Ribble Valley Borough Council
Housing & Development Control

Application no: **3/2024/0327**

Address: **Pendle Mill Pendle Road Clitheroe BB7 1JQ**

Proposal: **Outline application for demolition of existing buildings and erection of a care home (Use Class C2) with access, appearance, layout and scale applied for.**

Drawing Title  
Proposed Site Plan

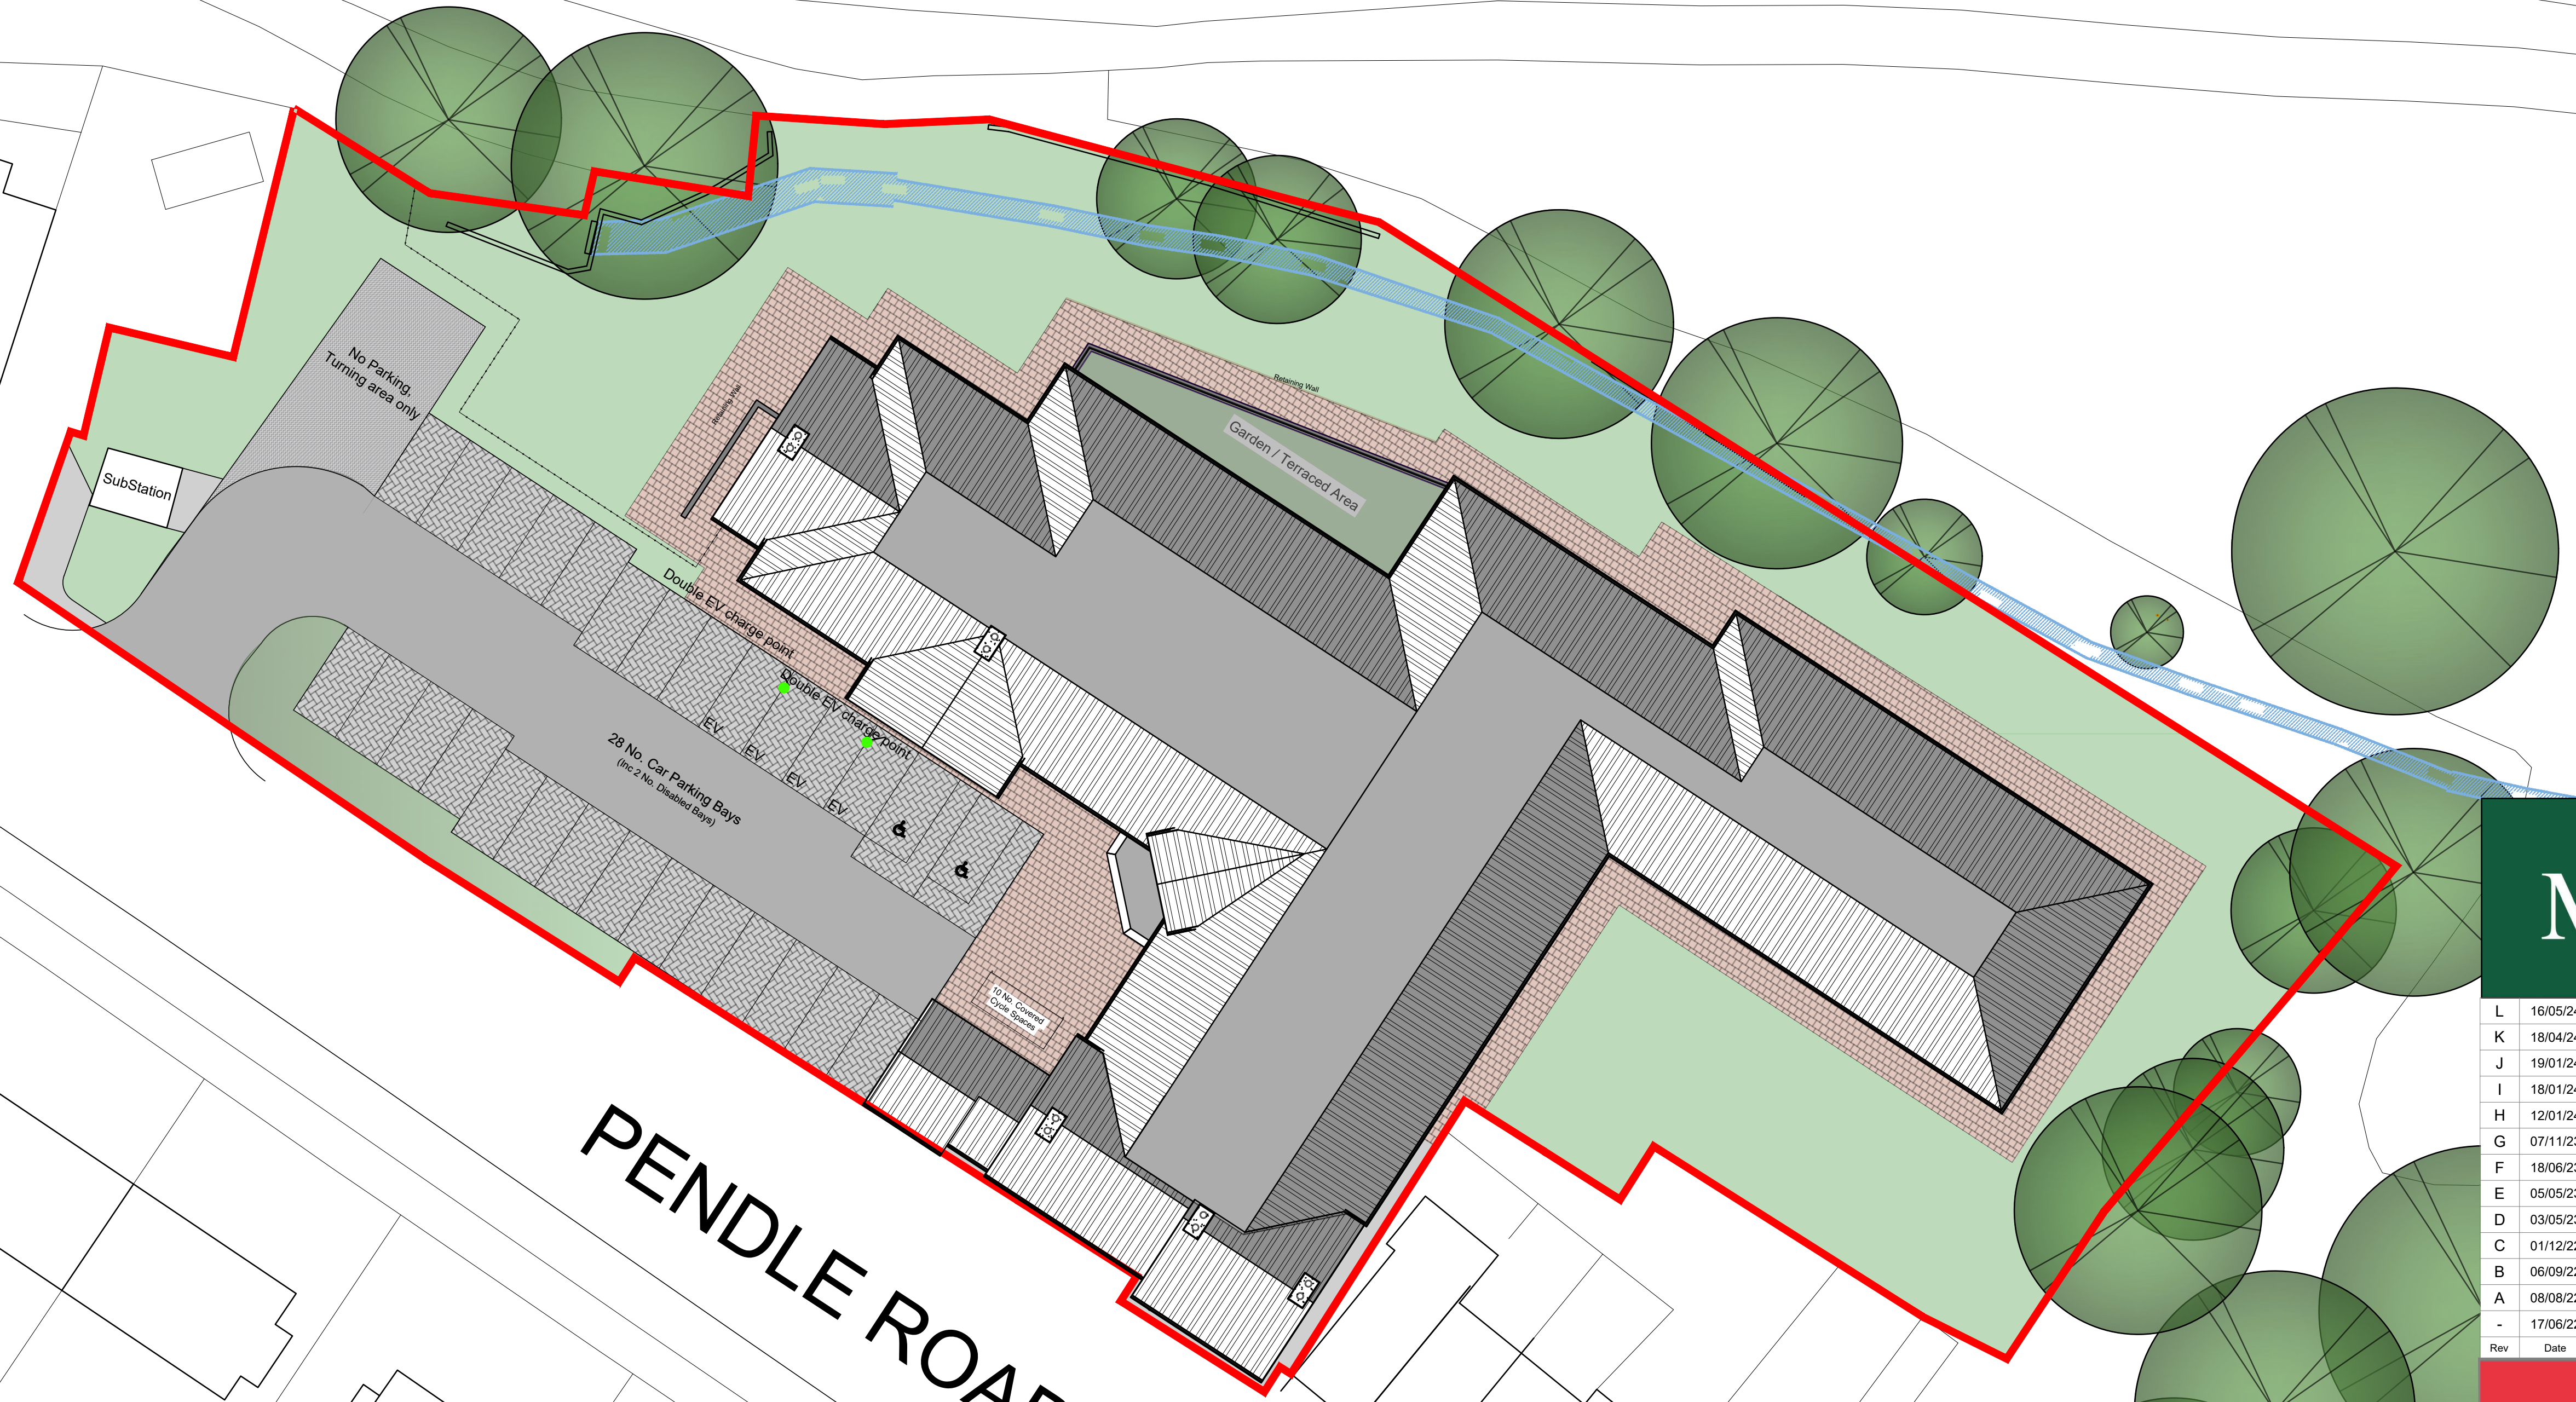
The LHA have reviewed ADG drawing number (9-)3 Rev L titled "Proposed Site Plan," and are aware that the existing access' will be stopped up with full height kerbs reinstated and a new access will be provided. The LHA have reviewed the drawing and the provided tracking drawings showing a refuse vehicle entering and exiting the site and are satisfied that the access width and kerb radii is safe and suitable to serve the proposal.

The LHA have reviewed ADG drawing number (9-)3 Rev L titled "Proposed Site Plan," and are aware that 28 car parking spaces will be provided for the proposal. This complies with the LHAs parking guidance as defined within the Joint Lancashire Structure Plan. The site will also provide 4 electric vehicle charging points, 10 cycle spaces and 2 disabled spaces which are all welcomed.

The LHA have also reviewed the tracking drawing showing a refuse vehicle entering and exiting the site and are satisfied that the turning area is adequately sized to enable a large vehicle to exit the site in a forward gear.

5.No part of the development hereby permitted shall be occupied until such time as the access arrangements shown on ADG drawing number (9-)3 Rev L have been implemented in full.

7. The development hereby permitted shall not be occupied until such time as the parking and turning facilities have been implemented in accordance with ADG drawing number (9-)3 Rev L. Thereafter the onsite parking provision shall be so maintained in perpetuity.
